KITTITAS COUNTY COMMUNITY DEVELOPMENT SERVICES

RE: Transmittal of Comments – Brain Short Plat (SP-13-00010)

TO: Jeff Watson, Community Development Services
FROM: Christina Wollman, Planner II *CW*
DATE: December 30, 2013
SUBJECT: Brain Short Plat SP-13-00010

CRUSE & ASSOCIATES
PROFESSIONAL LAND SURVEYORS
217 E. Fourth St. P.O. Box 959
Ellensburg, WA 98926 (509) 962-8242
BRAIN SHORT PLAT

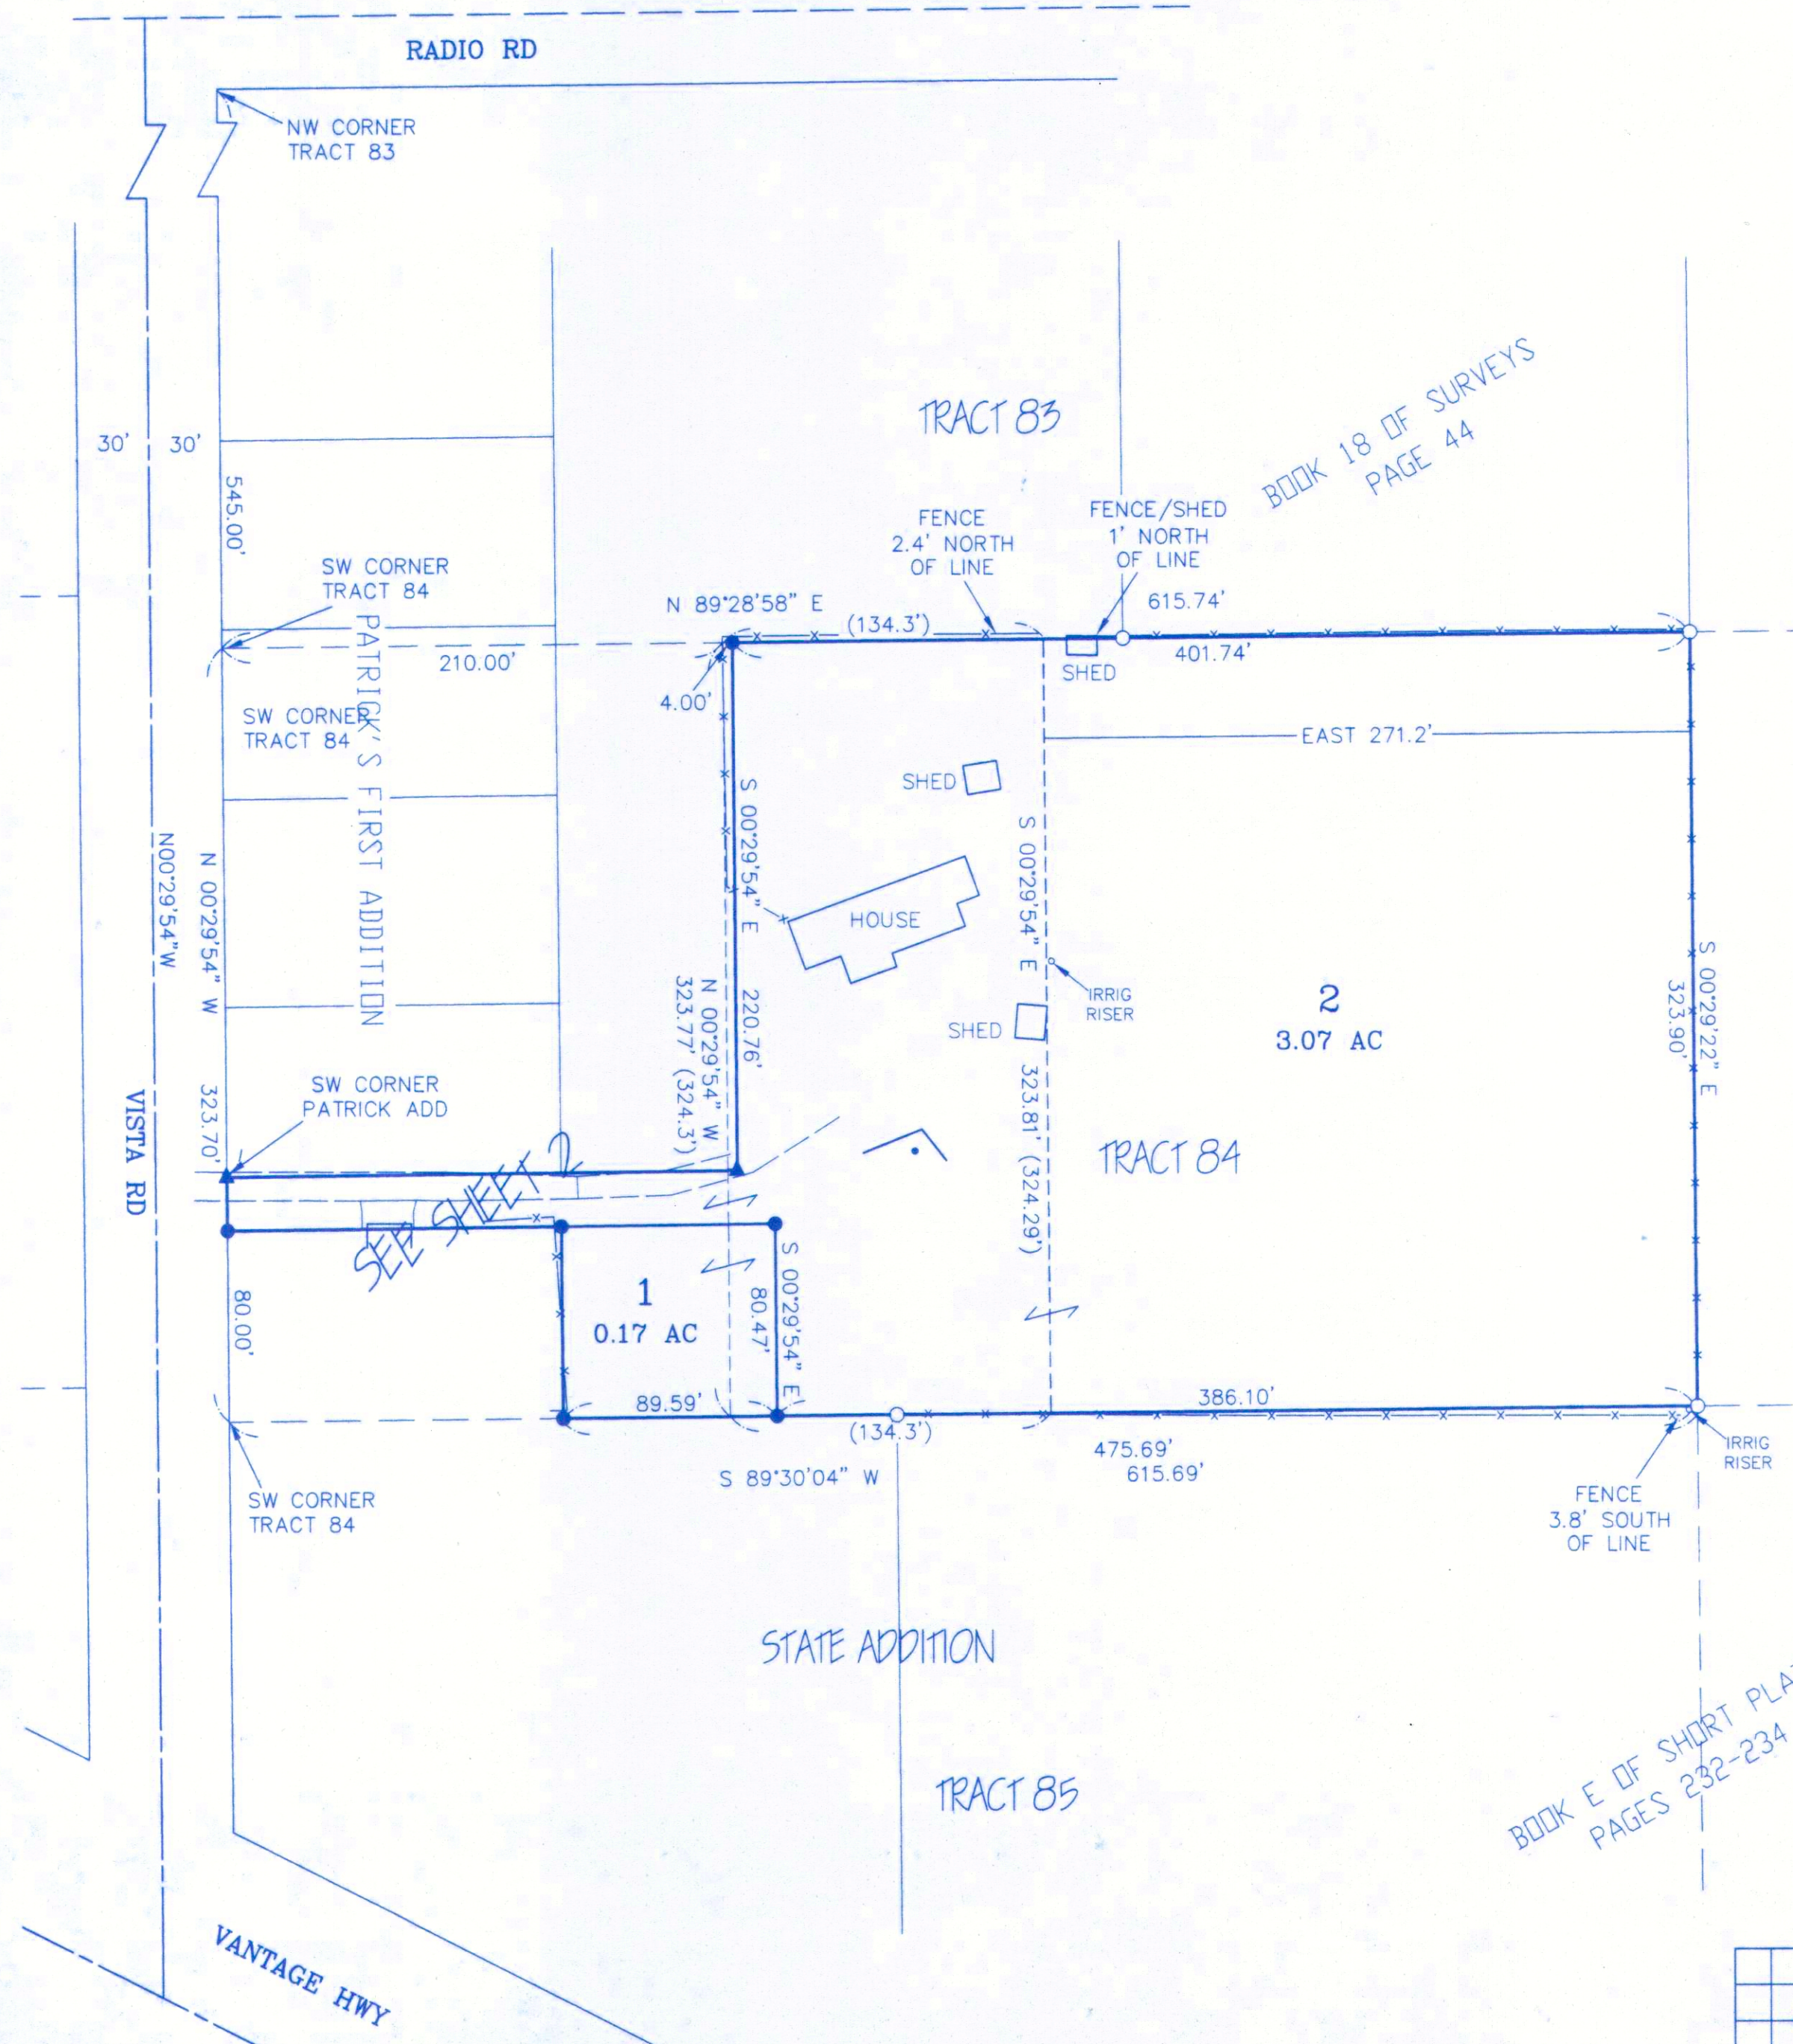
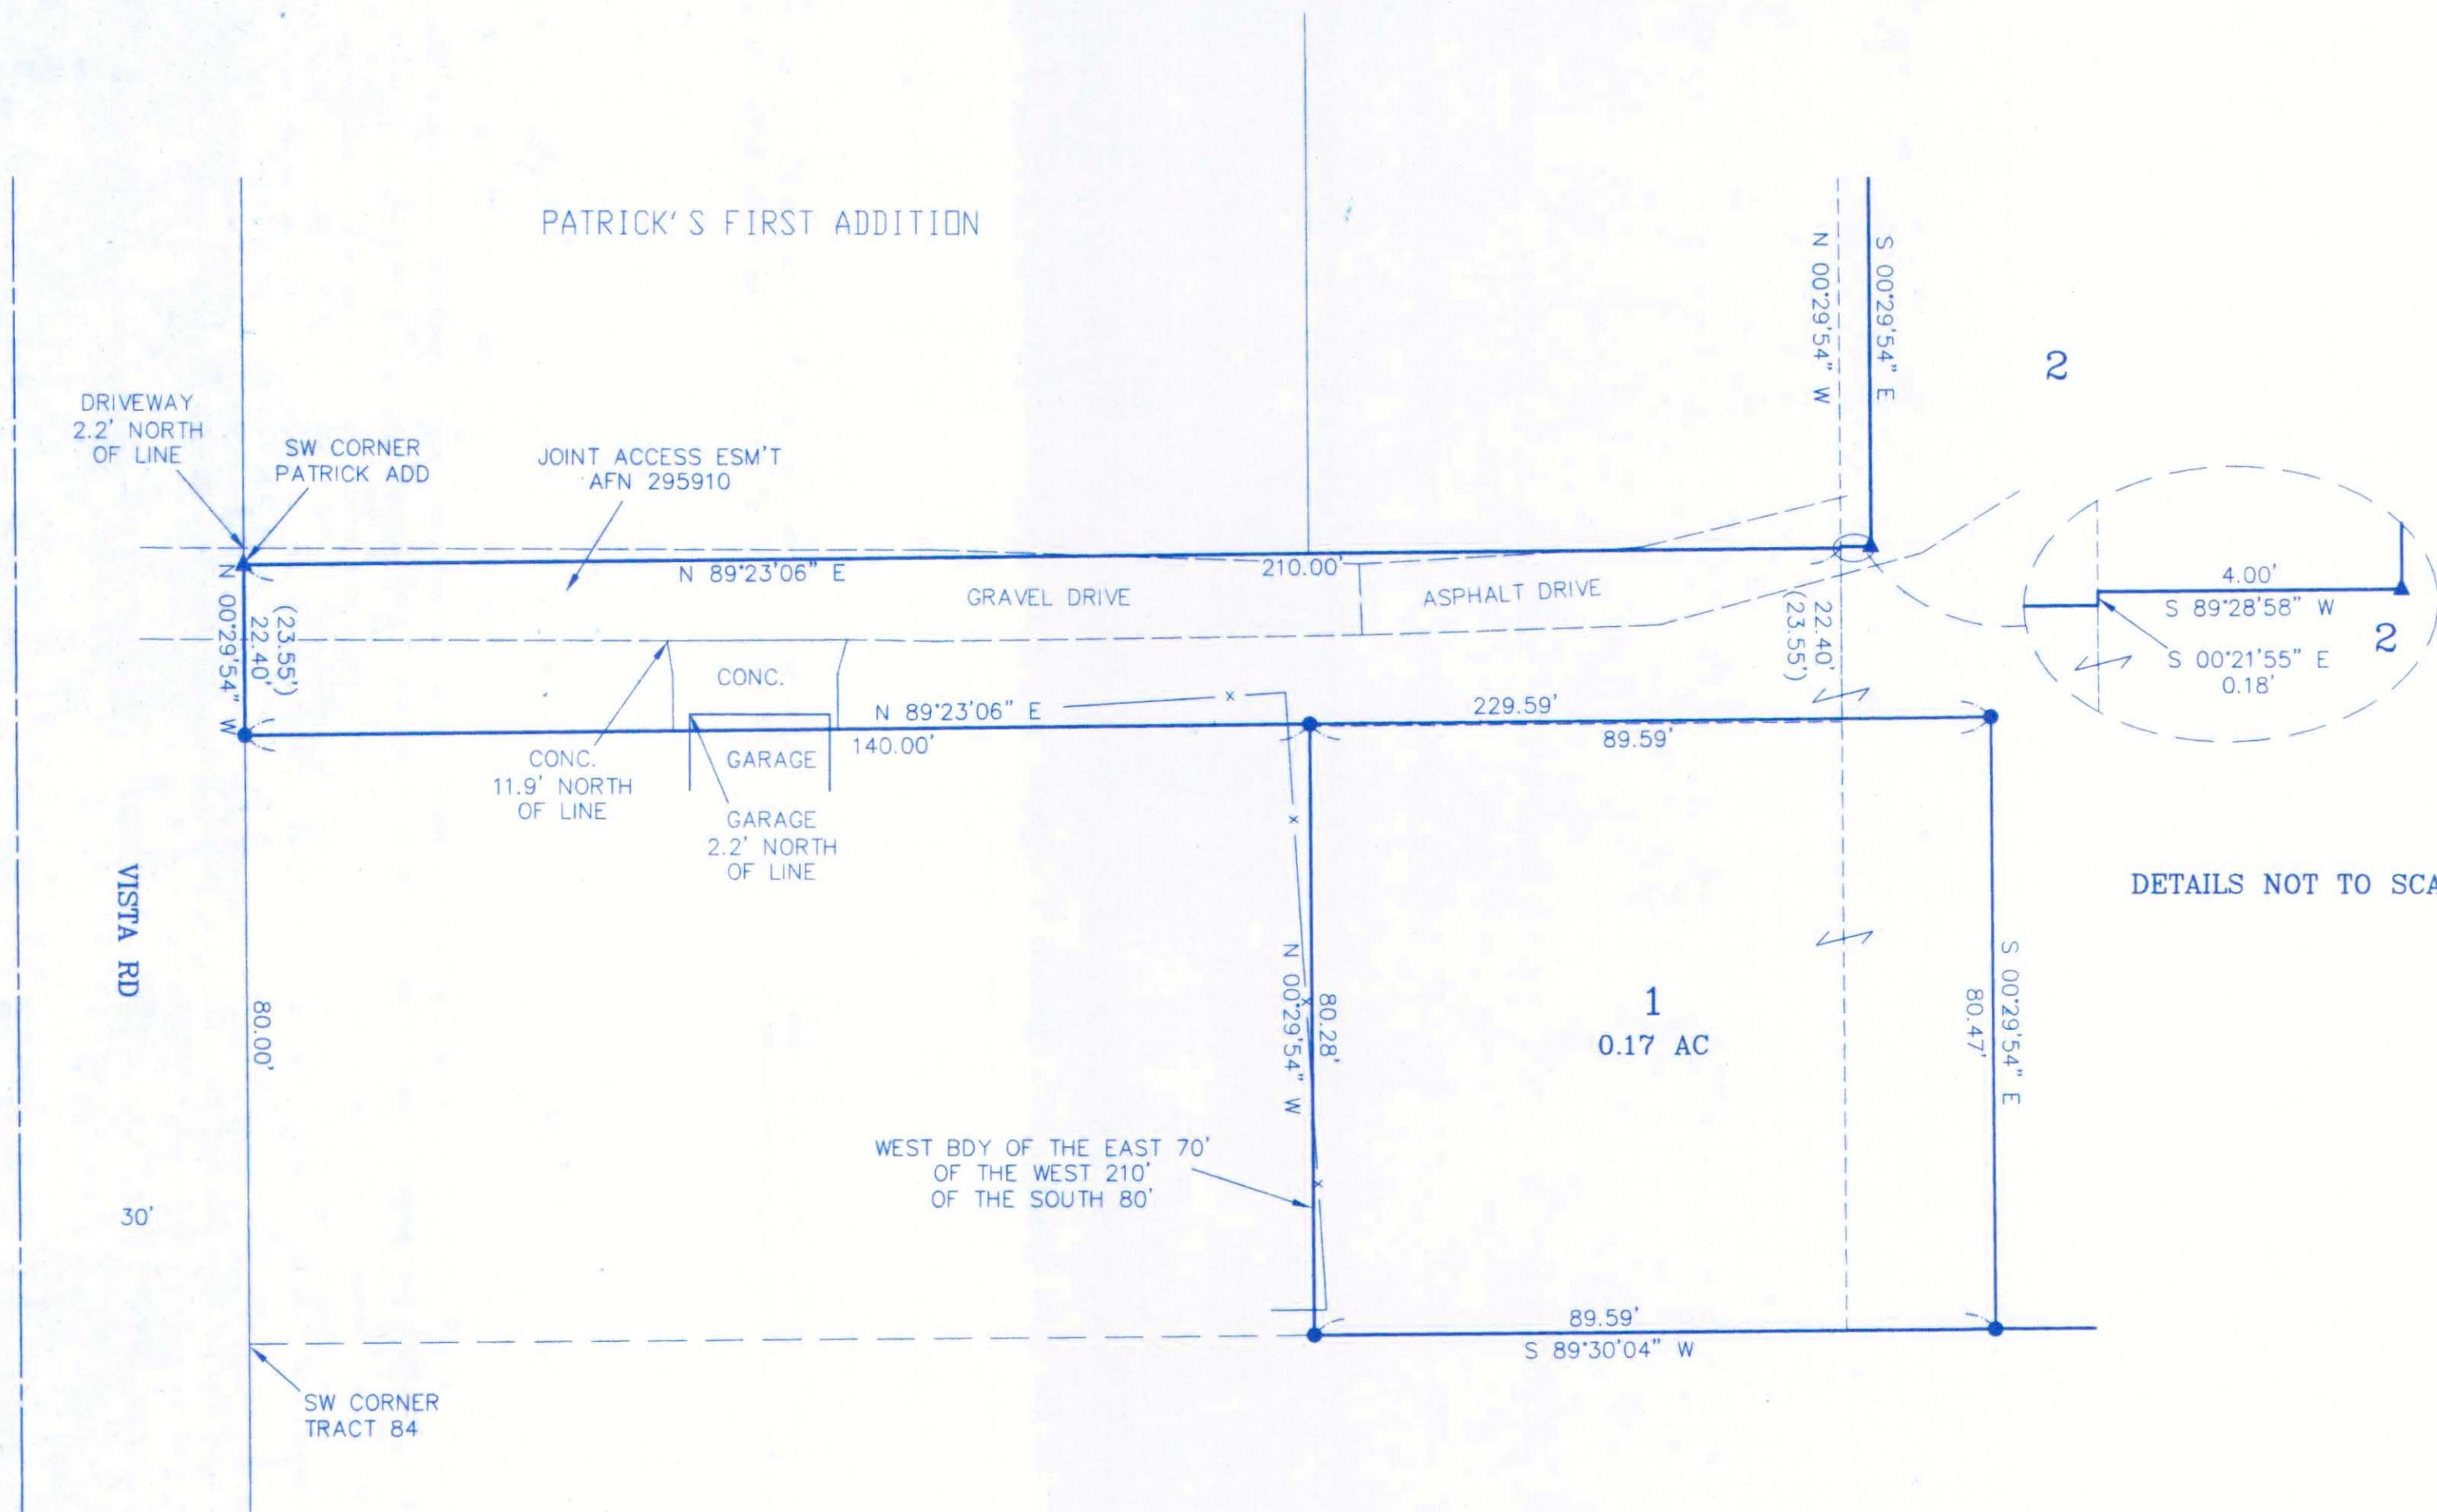
1. Road Variance (RV-13-14 Brain): This project received a road variance to allow reduced standards for the access road serving the project. The following conditions apply:

- a. The road shall be a minimum of 20' wide and have an allweather surface.
 - b. A turnaround shall be constructed in a location approved by the Fire Marshal.

- c. The road shall not be used for any future subdivision.
2. Vantage Highway Access: The landowner has secured a 60' easement from the Vantage Highway into the site. The driveway will access the Vantage Highway from the existing commercial access at 1601 Vantage Highway. If this access is used for the new lot instead of the driveway from Vista Road, the improvements required by RV-13-14 will not be required. The driveway from Vantage Highway must be constructed to meet the driveway standards in KCC 12.12 and KCC 20.02. Additional improvements will be required if the driveway receives use outside of this short plat or serves future development.
